Planning and Development Acts 2000 to 2020

Planning Register Reference Number: 0135/21

WHEREAS a question has arisen as to whether the construction of two number extensions to the rear of a house at number 3 Gilford Avenue, Sandymount, Dublin is or is not development or is or is not exempted development:

NOW THEREFORE An Bord Pleanála, in exercise of the powers conferred on it by section 5 (3) (a) of the 2000 Act, hereby decides that -

Plan and
 party wall elevation
 March 2021

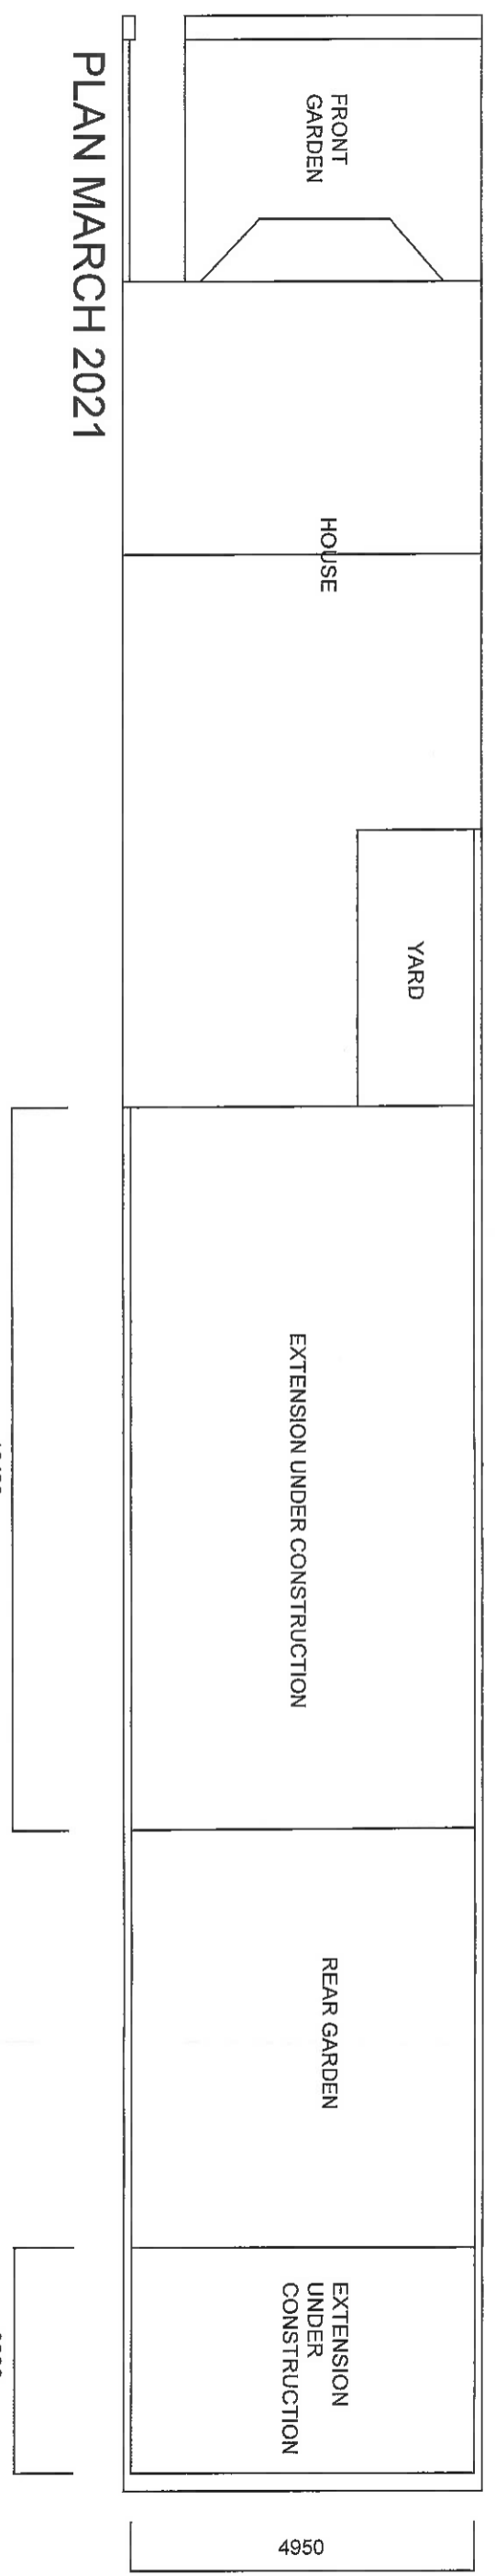
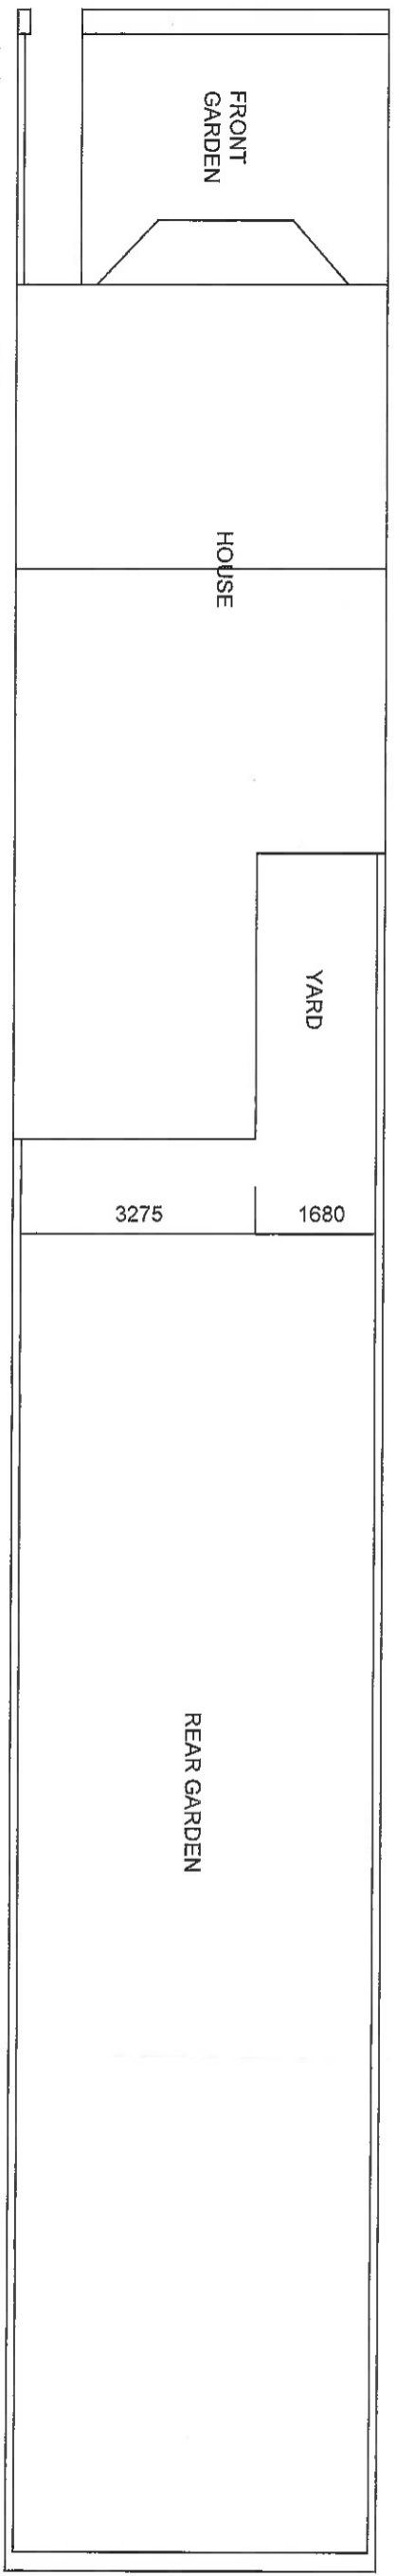
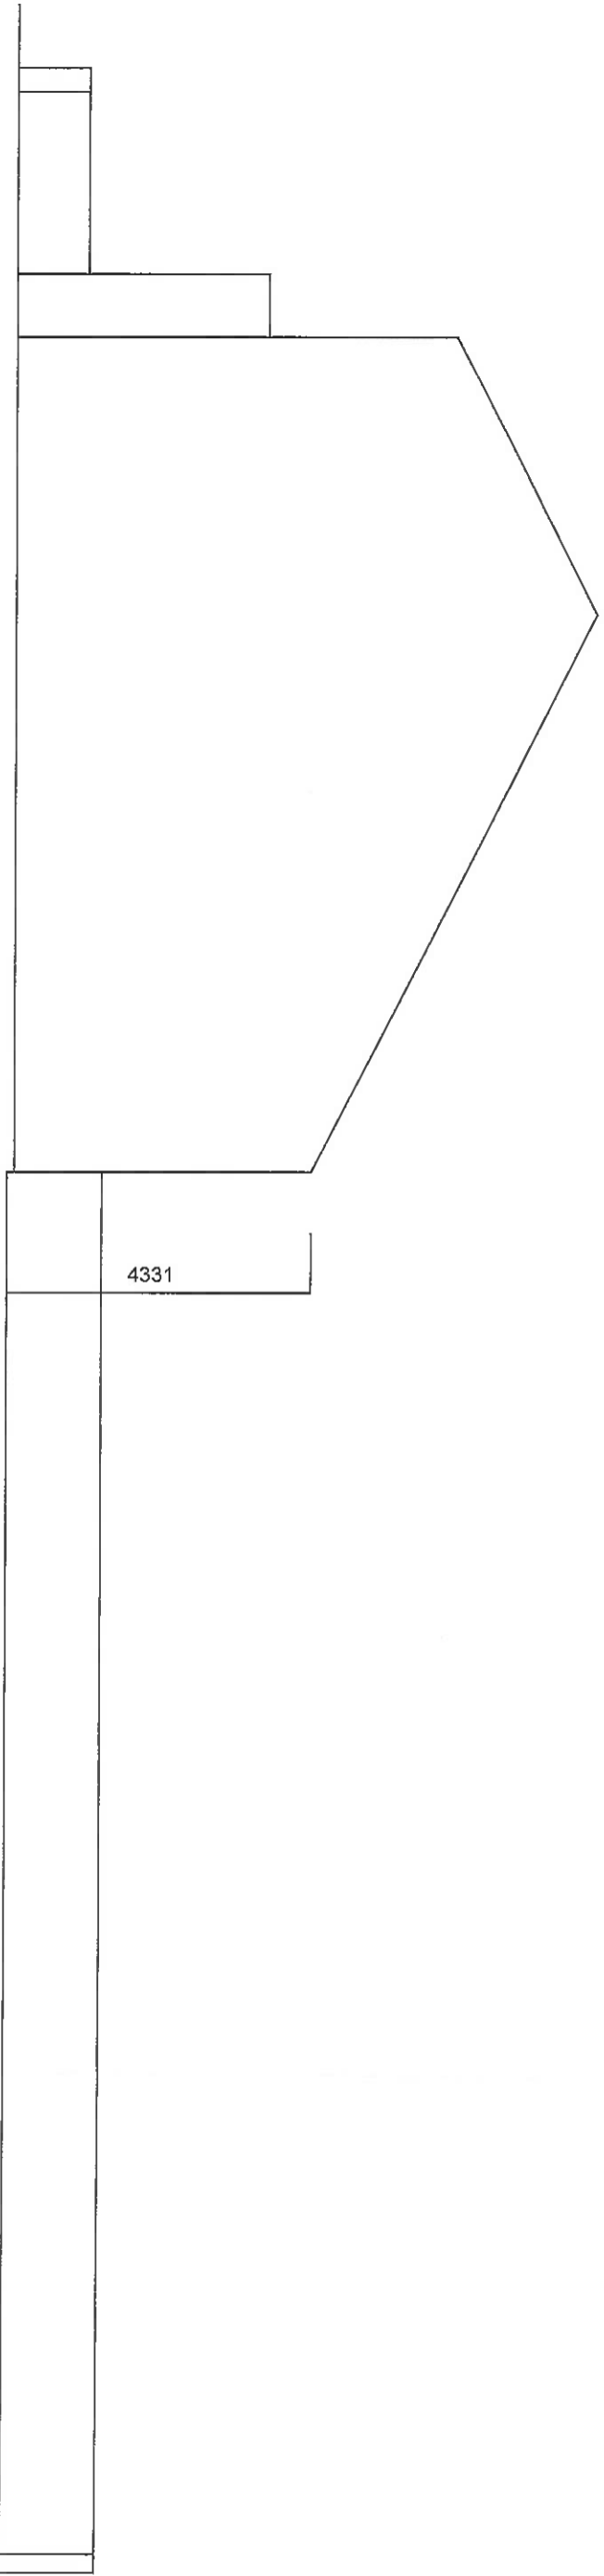
- (a) the construction of the extension to the house and the shed constitutes development,
- (b) the height of the wall of the subject extension exceeds the height of the rear wall of the house,
- (c) the subject extension, as constructed, does not comply with the conditions and limitations of (4)(a) as set out in Column 2 of Class 1 of Part 1 of Schedule 2 of the Planning and Development Regulations, 2001, as amended, and

- (a) the construction of an extension to the rear of dwelling at number 3 Gilford Avenue, Sandymount, Dublin is development and is not exempted development, and
- (b) the construction of the shed to the rear of the dwelling at number 3 Gilford Avenue, Sandymount, Dublin is development and is exempted development.
